Thanet Extension Offshore Wind Farm

Annex A to Appendix 27 to Deadline 6 Submission:
Response to MMO D5a submission on seasonal
restriction

Date: May 2019

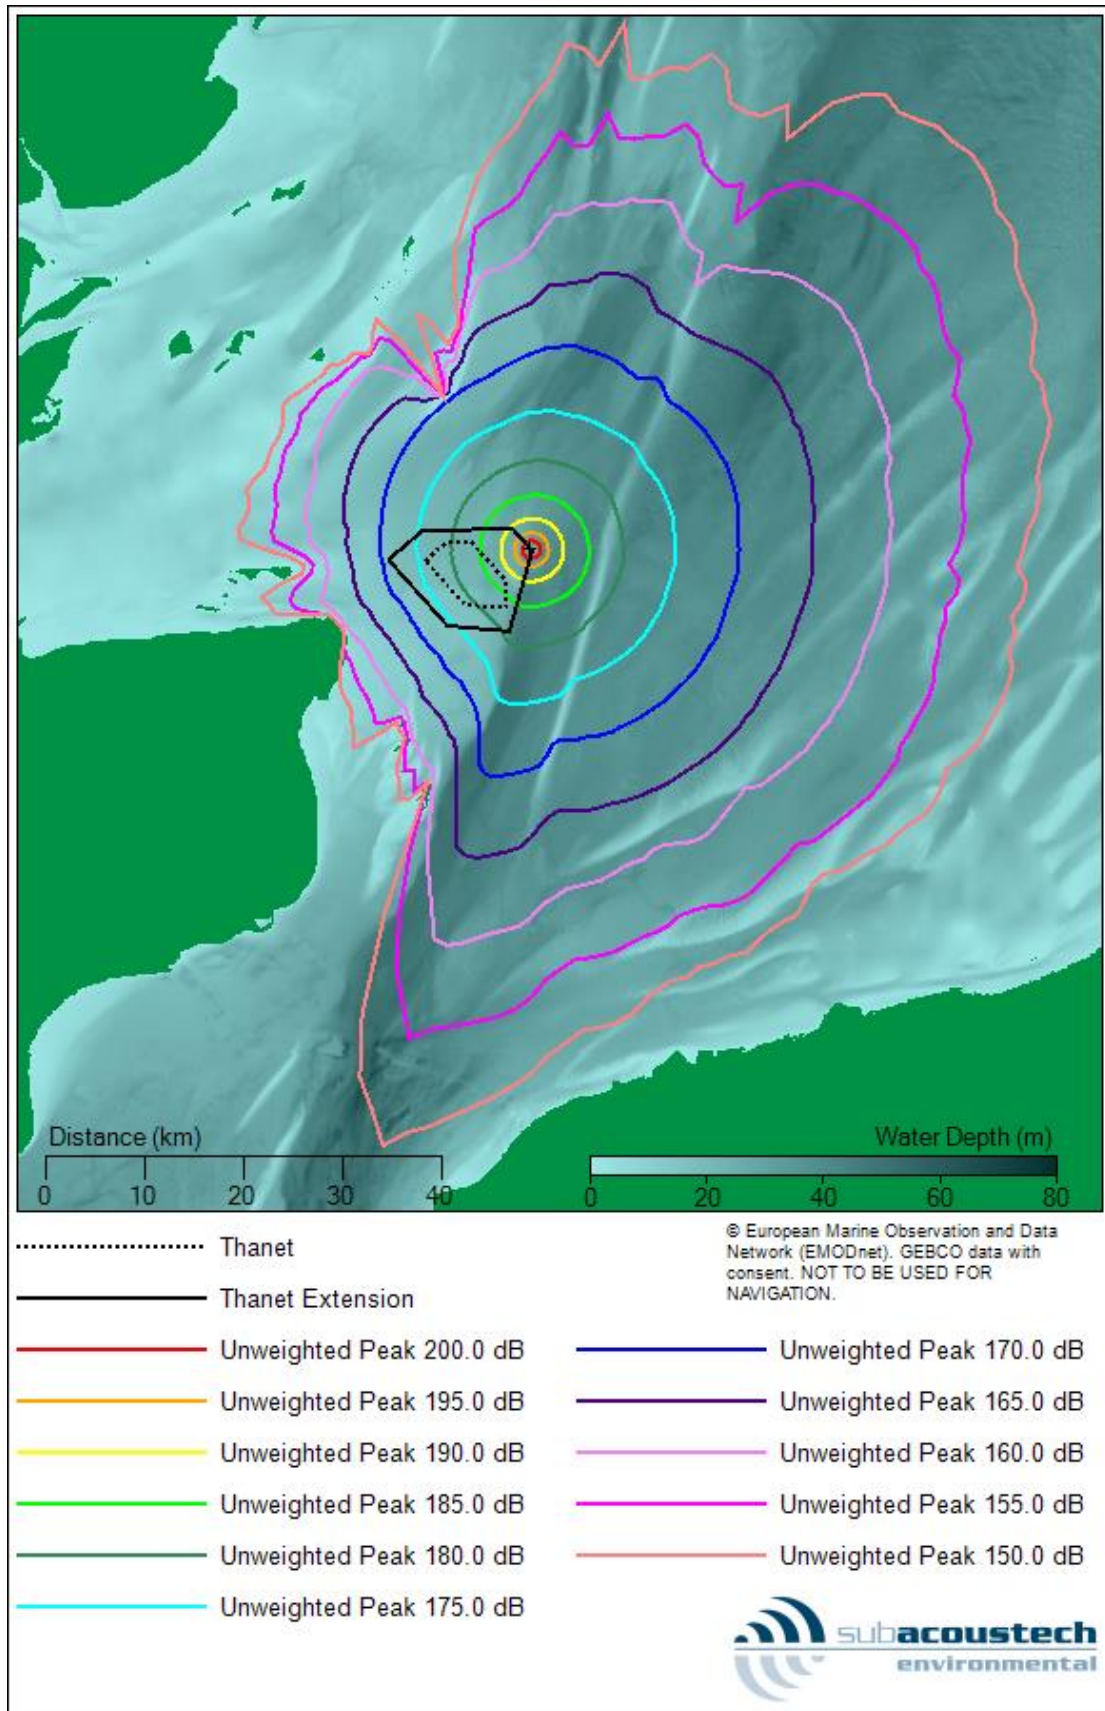
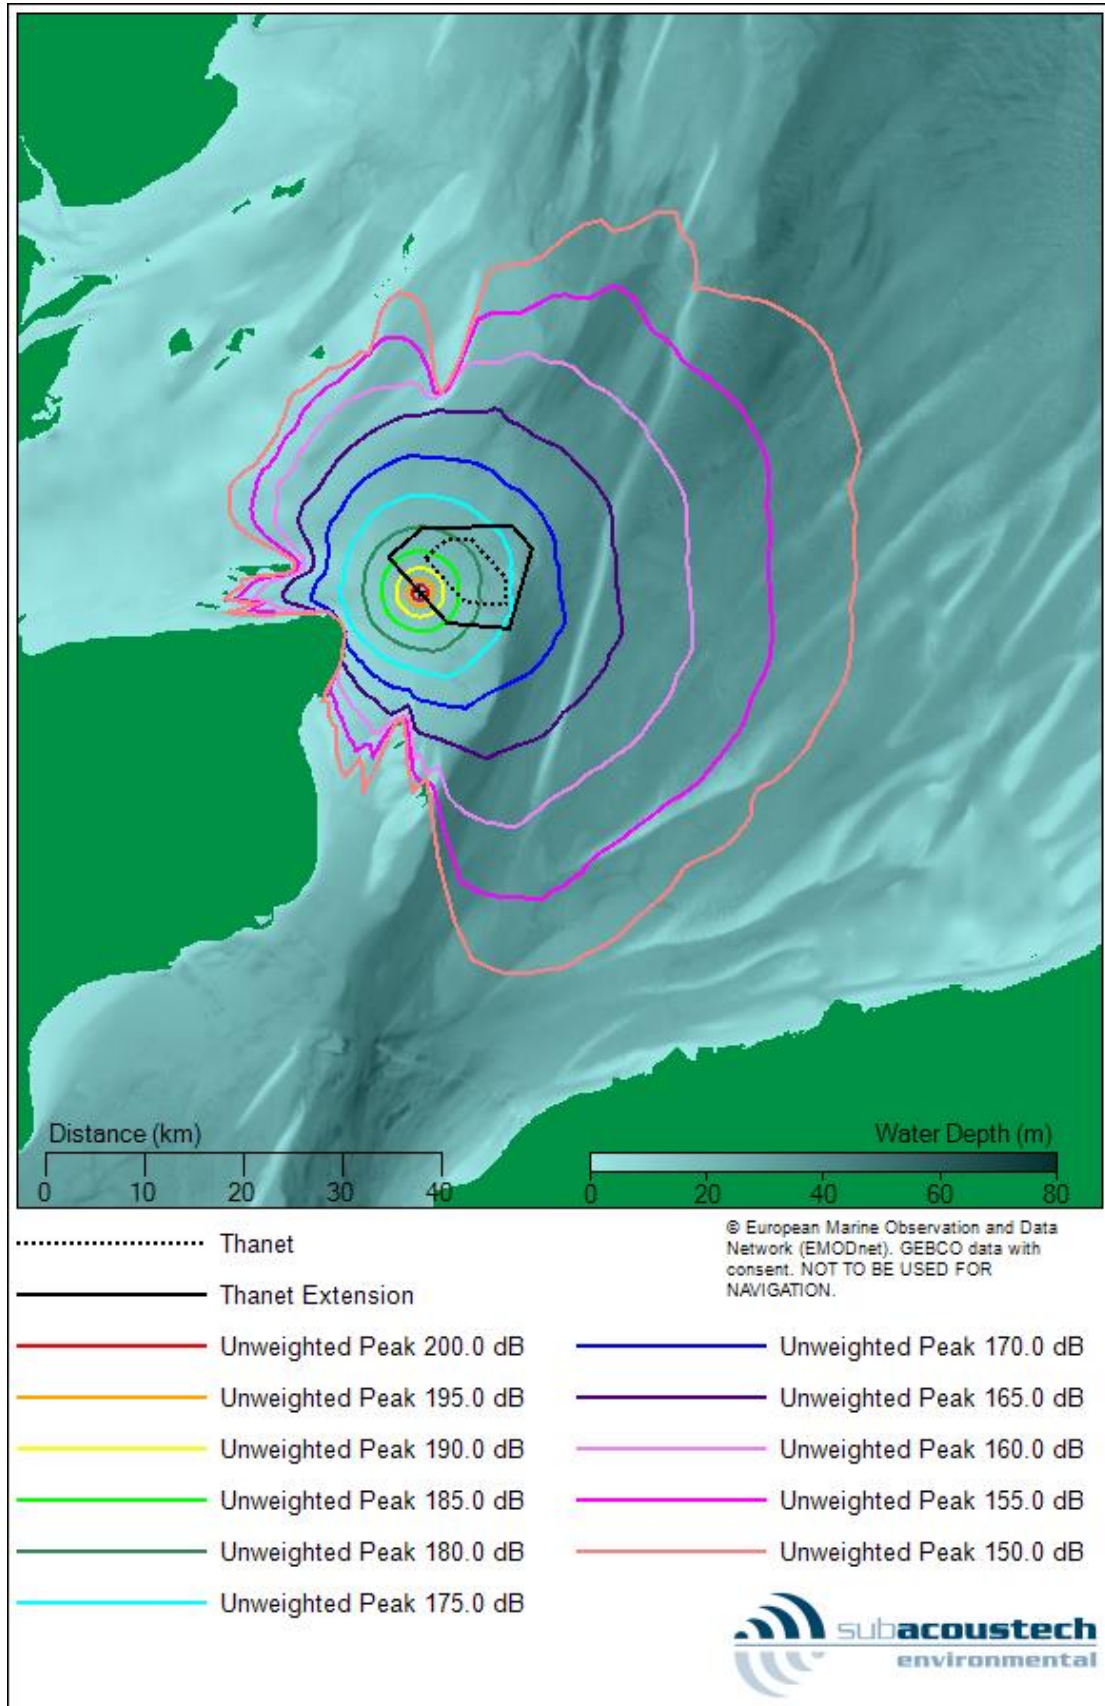
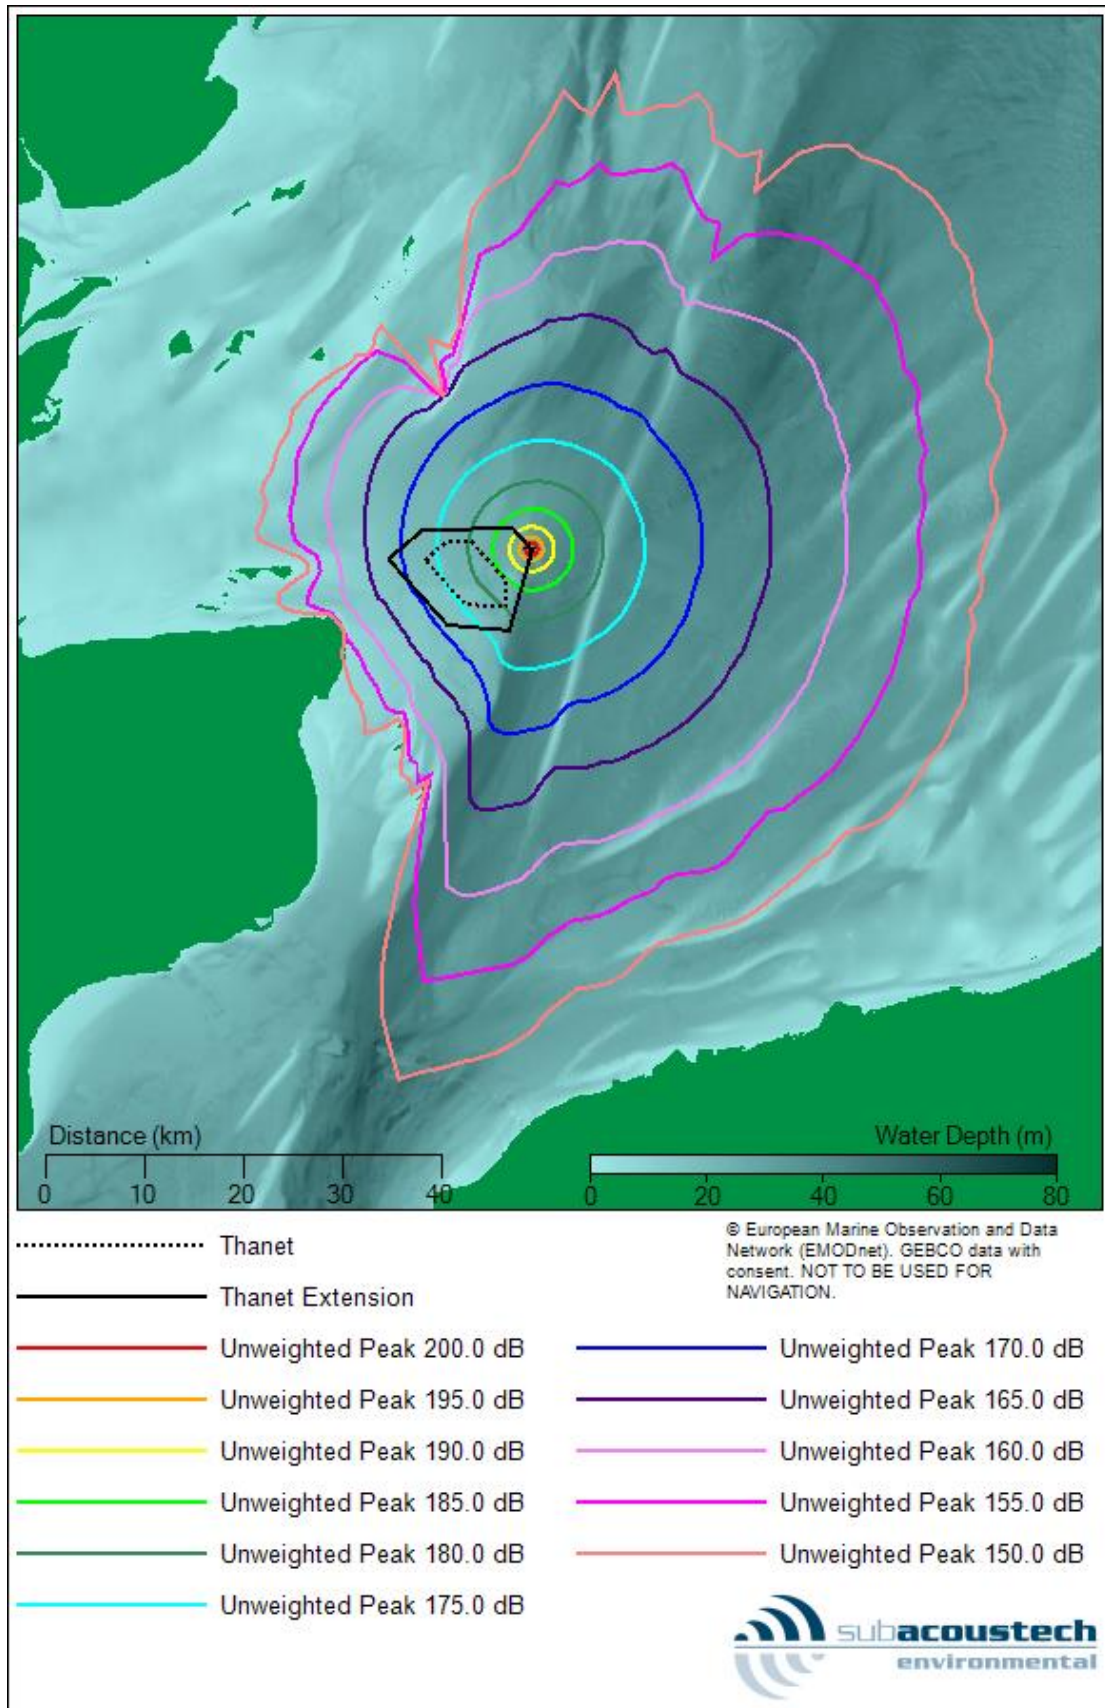
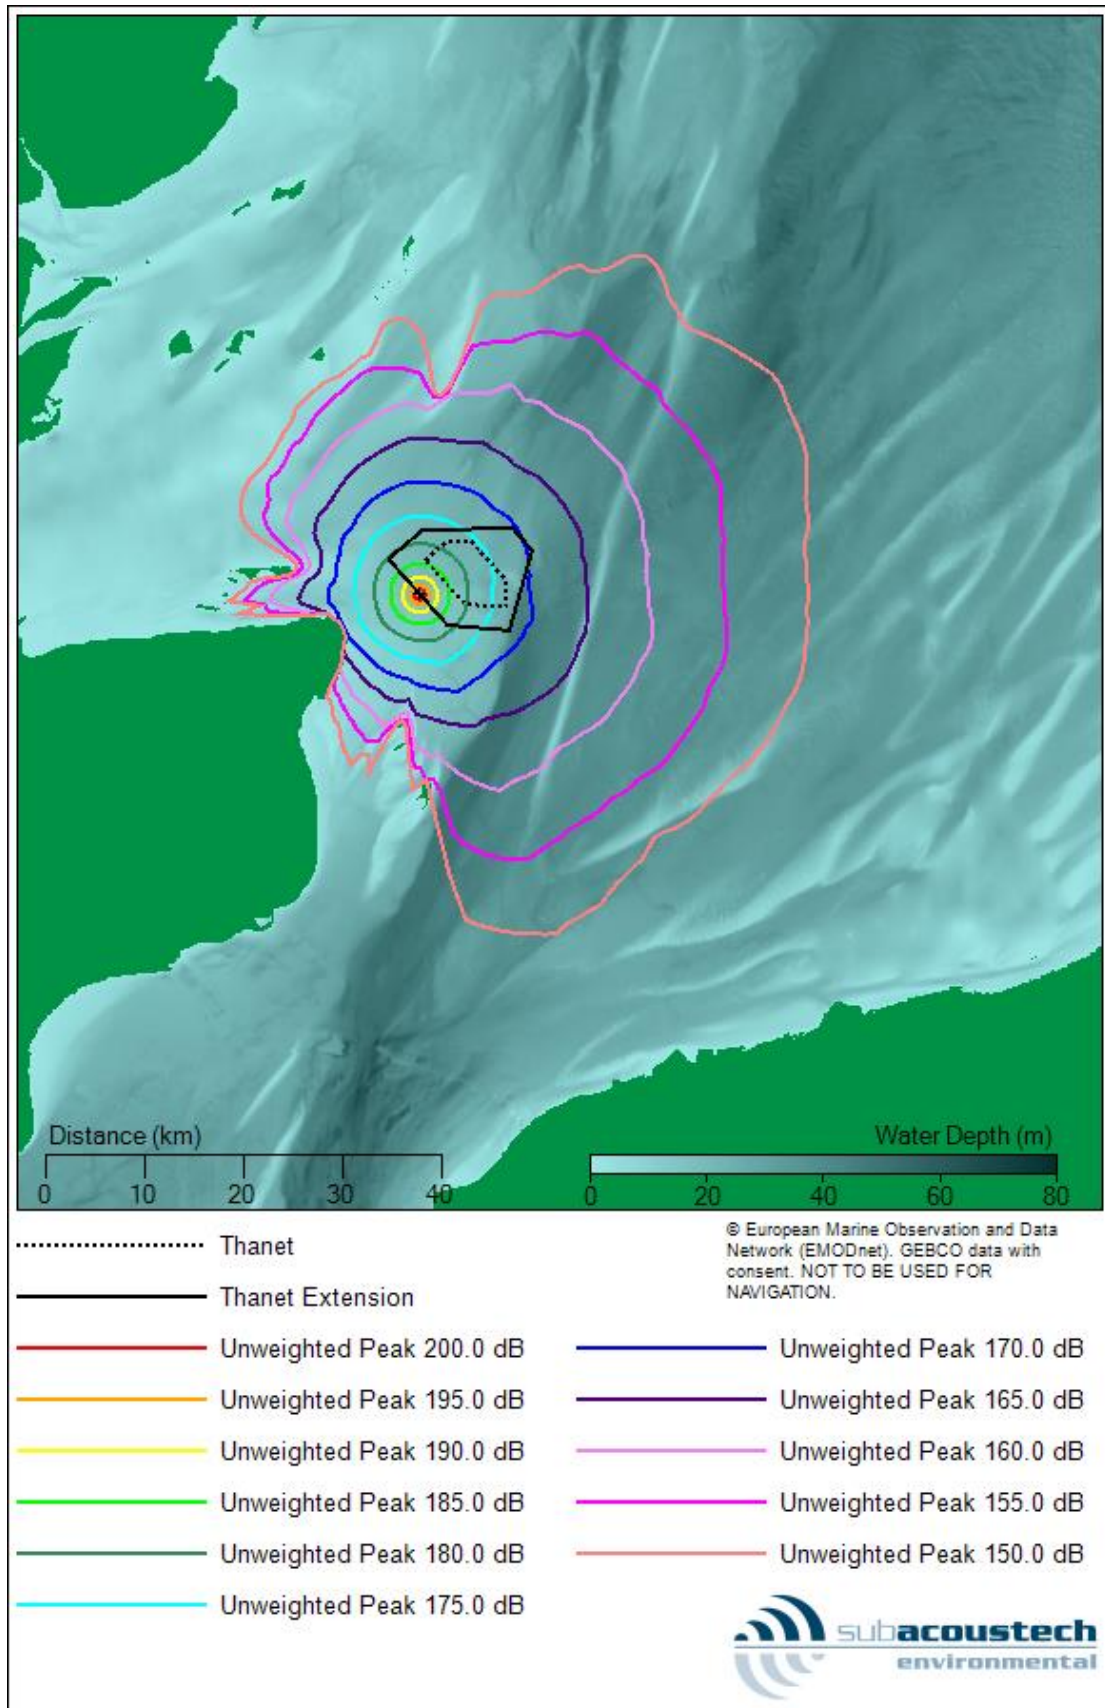
MMO Representation	Applicant response
<p>2.2 Herring spawning grounds</p> <p>2.2.1 The modelling shows that significantly larger impact ranges are predicted, based on a stationary receptor. The modelling suggests that the predicted impact ranges for mortality, recoverable injury and Temporary Threshold Shift (TTS) (207dB, 210 dB and 186 dB SELcum) will overlap with areas of higher importance for herring spawning (East Channel (Downs) stock). The 186 dB SELcum metric has the largest overlap with the spawning grounds.</p>	<p>The Applicant notes that this statement refers to the East Channel (Downs) Stock to the east of the site which was identified by Coull et al (1998), a paper that provides estimates of spawning ground locations using sediment type and discrete survey data. The Applicant has submitted a more recent dataset which draws on 10 years of International Herring Larval Survey (IHLS) data which confirms that the nearest spawning grounds to the site are ~25 km to the south (Figure 1, Appendix 7 to the Applicant’s D4C submission). The Applicant notes that this appears to infer that the spawning grounds identified in Coull et al (1998) have shifted such that the areas of the North Sea/ English Channel in close proximity to the proposed project are now of lesser importance. Equally it could infer that the comparatively limited dataset utilised in Coull et al (1998) identified an infrequent spawning area that is not reflected in longer terms datasets collected since.</p>

MMO Representation	Applicant response
	 <p>The Applicant also notes that the modelled outputs demonstrate that the presence of the Margate Sands sandbank acts as a barrier to underwater noise propagation. Given the location of the Thames sub-stock (should it still exist) to the west of the sandbank features, combined with the modelled underwater noise outputs, the Applicant does not believe that a seasonal restriction is required given the likely scale of effect.</p>
<p>2.2.6 This recommendation further recognises that the Thanet OWF was similarly subject to a temporal piling restriction as part of the licence conditions. The evidence provided suggests there is no reason that Thanet Extension should not be subject to the same condition.</p>	<p>The Applicant notes that the MMO appear to be drawing on the precedents set at Thanet OWF, which was subject to a restriction from November to January. The Applicant notes that the MMO review of post-consent monitoring for OWFs also confirms that a restriction at Thanet OWF was removed. The Applicant further notes that this restriction was based on Coull <i>et al</i> 1998 data which the applicant has stated should now be considered to</p>
